**KIRKLEES METROPOLITAN COUNCIL
INVESTMENT & REGENERATION SERVICE**

Reference No:	2025/44/93448/W
Site Address:	26, Westgate, Honley, Holmfirth, HD9 6AA
Description:	Discharge of details reserved by condition 3 (windows) on previous permission 2025/92346 for change of use from residential (use class C3) to beauty salon (use class E) with associated alterations (Listed Building within a Conservation Area)
Recommending Officer:	Elenya Jackson

DECISION – REFUSE DISCHARGE OF CONDITIONS

Officer Report

Site: **26 Westgate, Honley**  
 Title: **Window Details (Sheet 3 of 4)**  
 Drawing No: **25-03-DC-03**  
 Revision: **a**

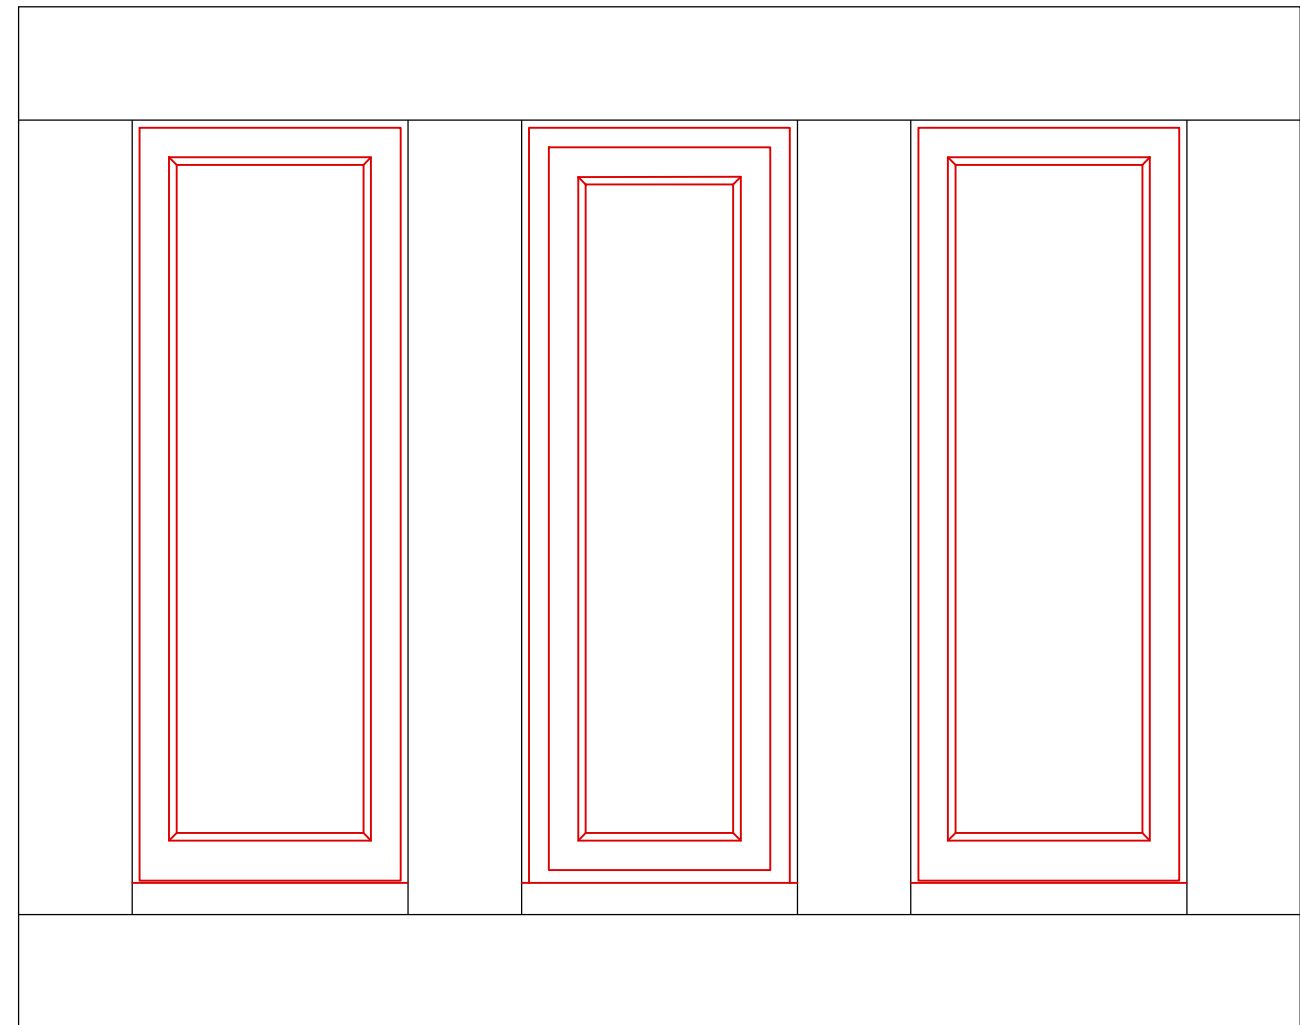
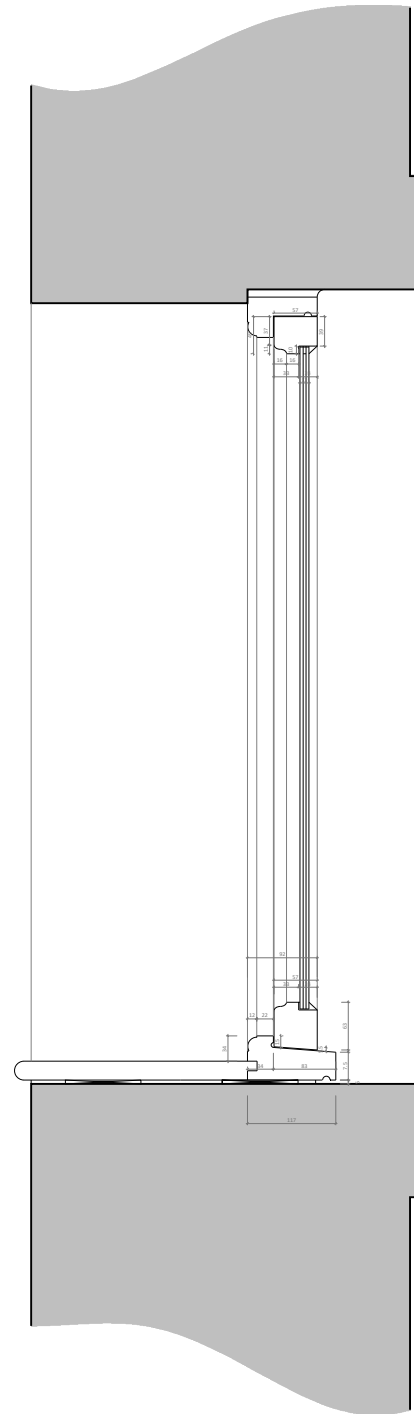
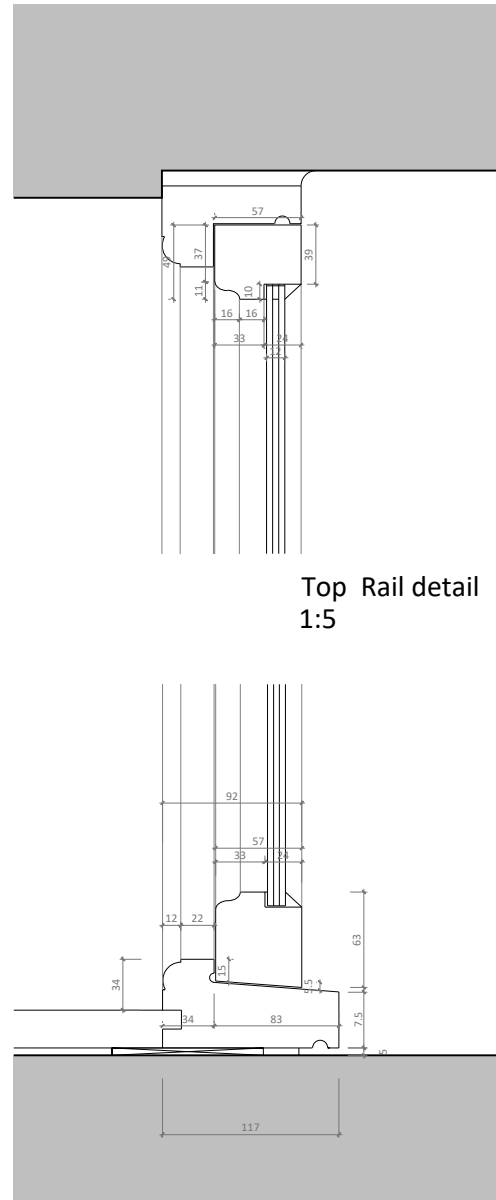
The details have been reviewed by KC Conservation and Design and have been considered acceptable. However, the applicant is reminded that windows should be recessed 100-150mm, butt hinges should be used opposed to friction stays and there should be no visible trickle vents. The details are considered acceptable for the purpose of condition 3 and the proposal should be carried out in accordance with the approved details.
